Request for advice for Fort Street Public School Mod 1 – Design and layout changes (SSD 10340 Mod 1)

Thank you for inviting comments from the Heritage Council of NSW on the above modification to the approved State Significant Development (7 October 2020). Heritage NSW is providing this delegated response, noting that this proposed modification involves changes to the design of buildings, including rooftop and circulation areas, landscaping and vehicular access arrangements including:

Heritage NSW

20 May 2021

/ South Elevation Building J/H

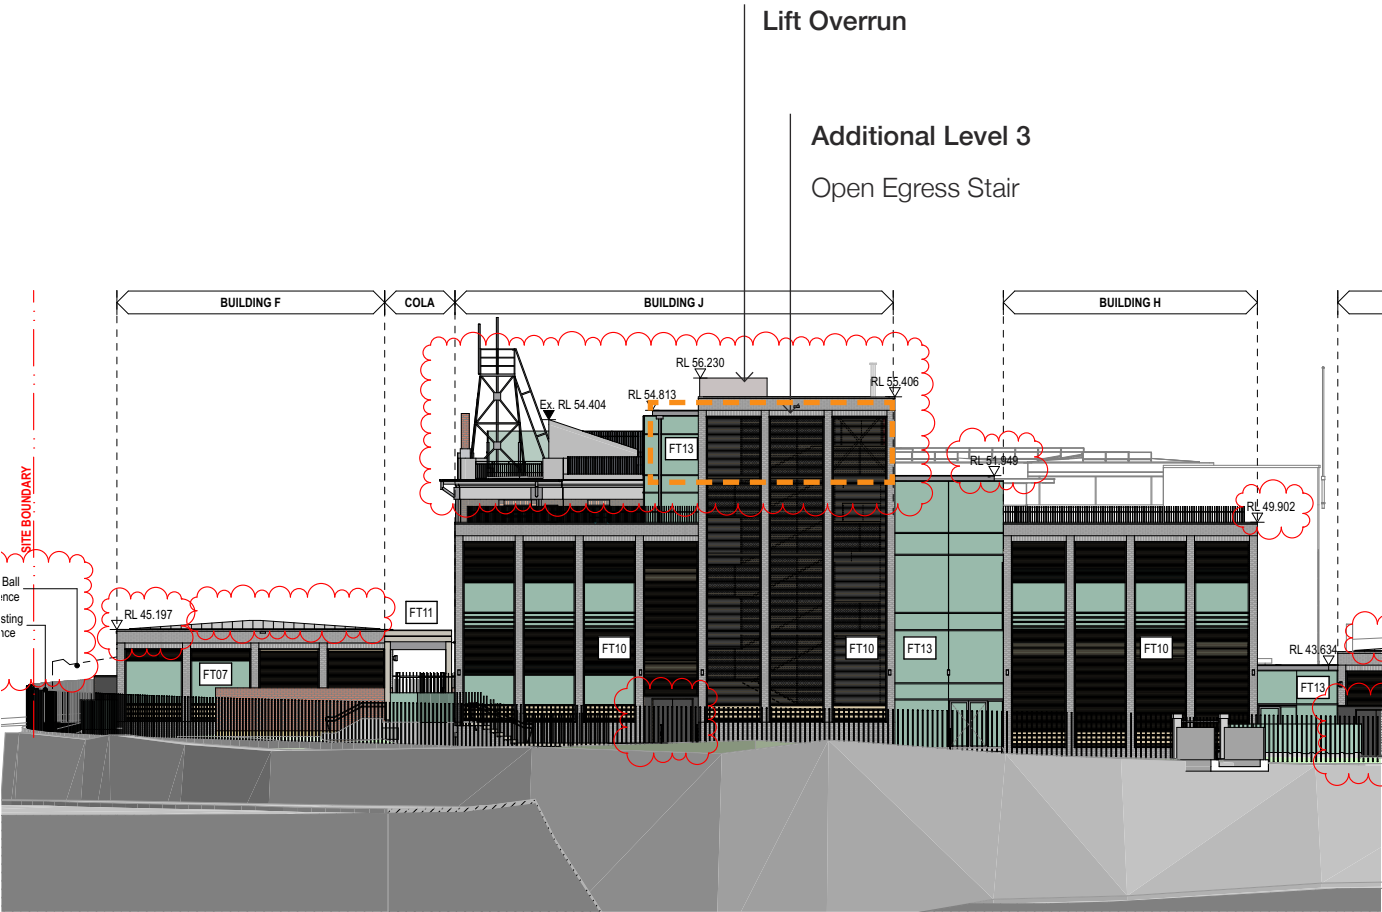
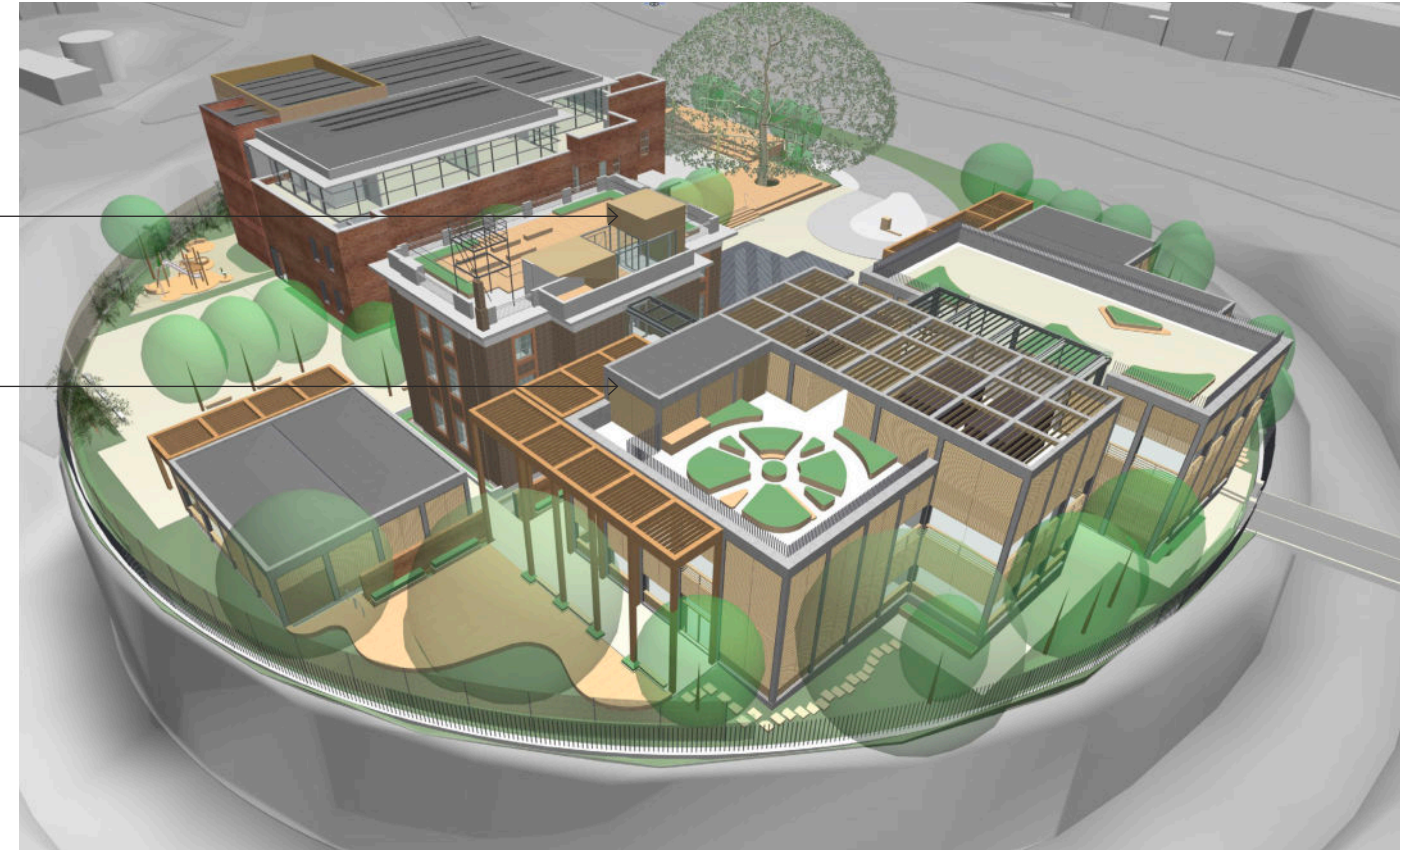
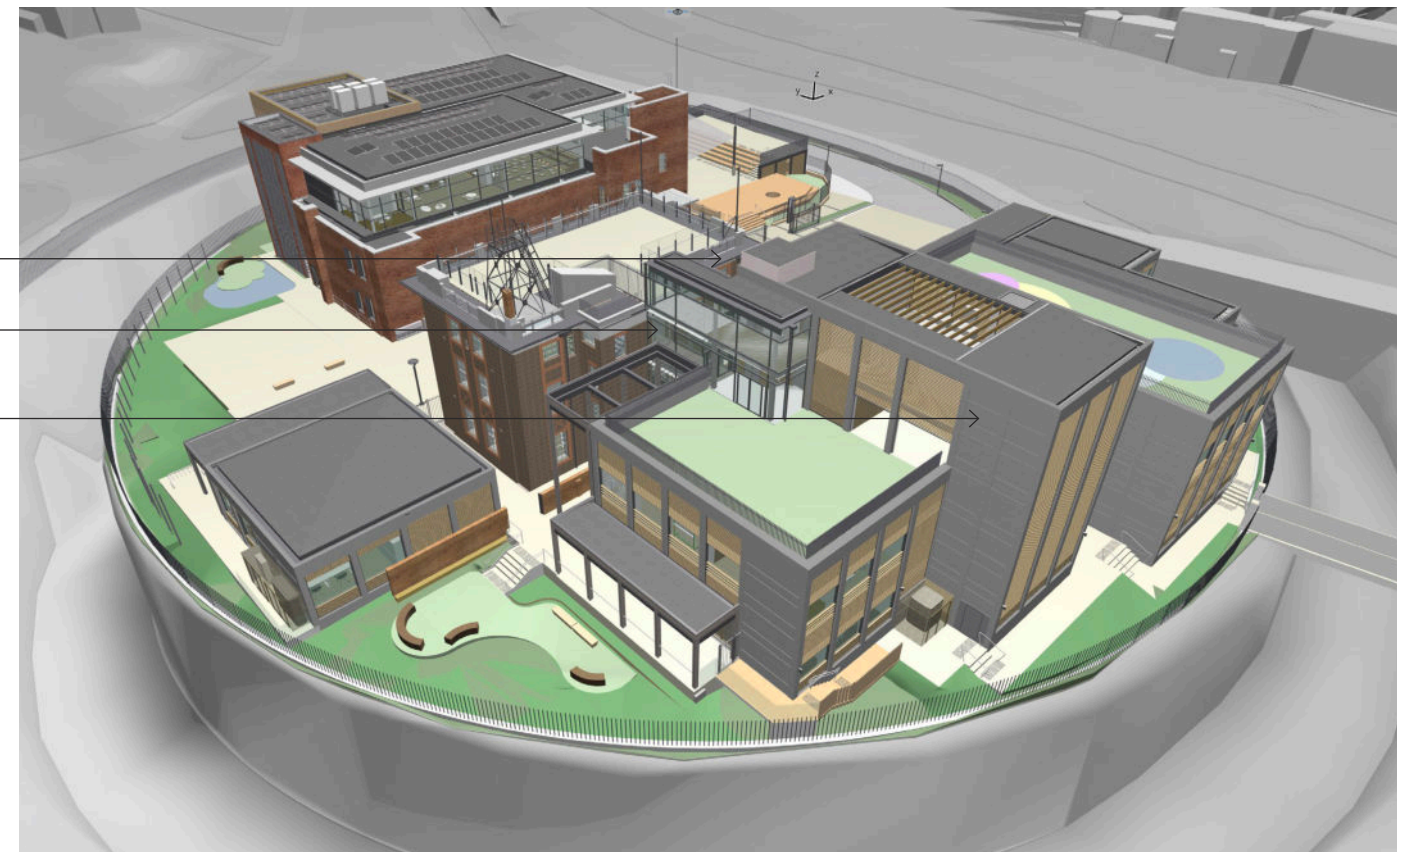
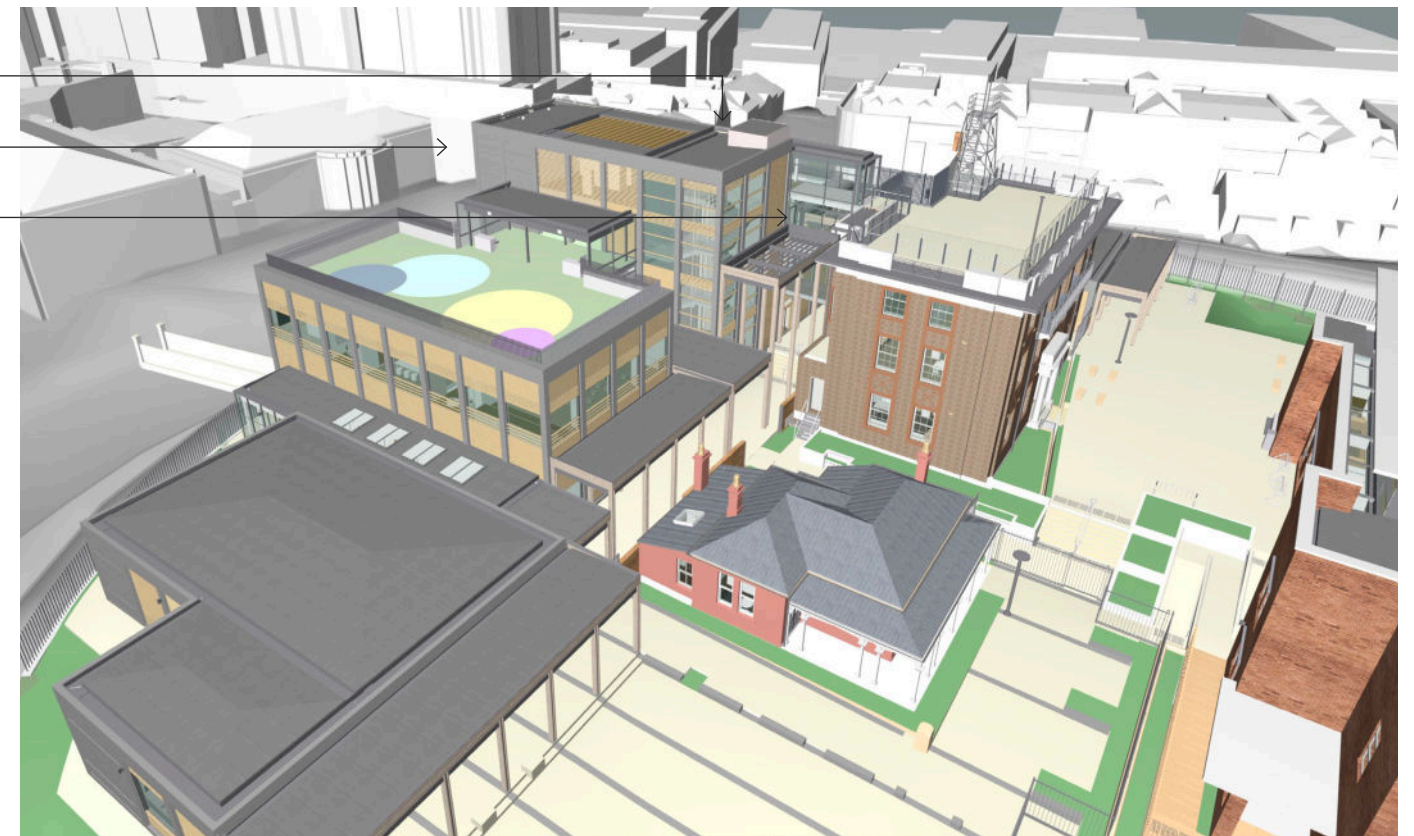
However, the modification to Building J increases the form, bulk, height and scale of Building J. This will have additional visual impact on the views and vistas to/from the FSPS site and Observatory Hill.

The proposed modification to Building J therefore does not comply with the CMP. The proposal will make Building J the dominant building at the FSPS site and Observatory Hill which is a sub-optimal heritage outcome. This has an additional visual impact on the views and vistas to Observatory Hill as well as impacting the visual and historical relationship between the National Trust Centre (former school building) and the 1940s school building at FSPS site.

/ S4.55 - Lower Ground Floor Plan

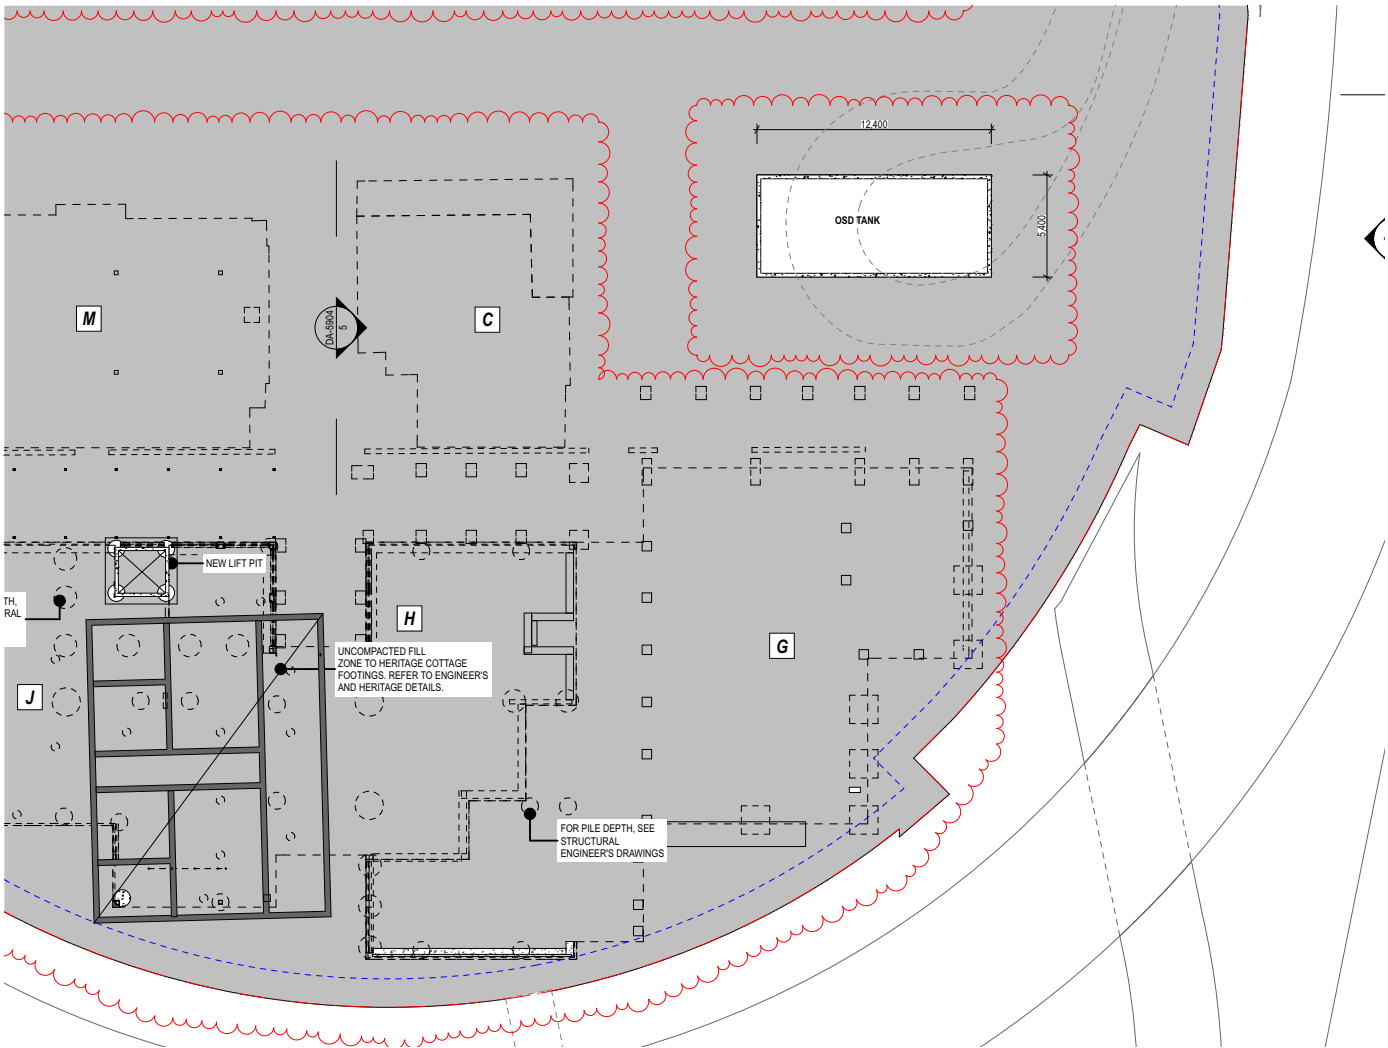
I note that the modification reduced the quantum of excavation and this is a positive outcome for conservation of archaeology.
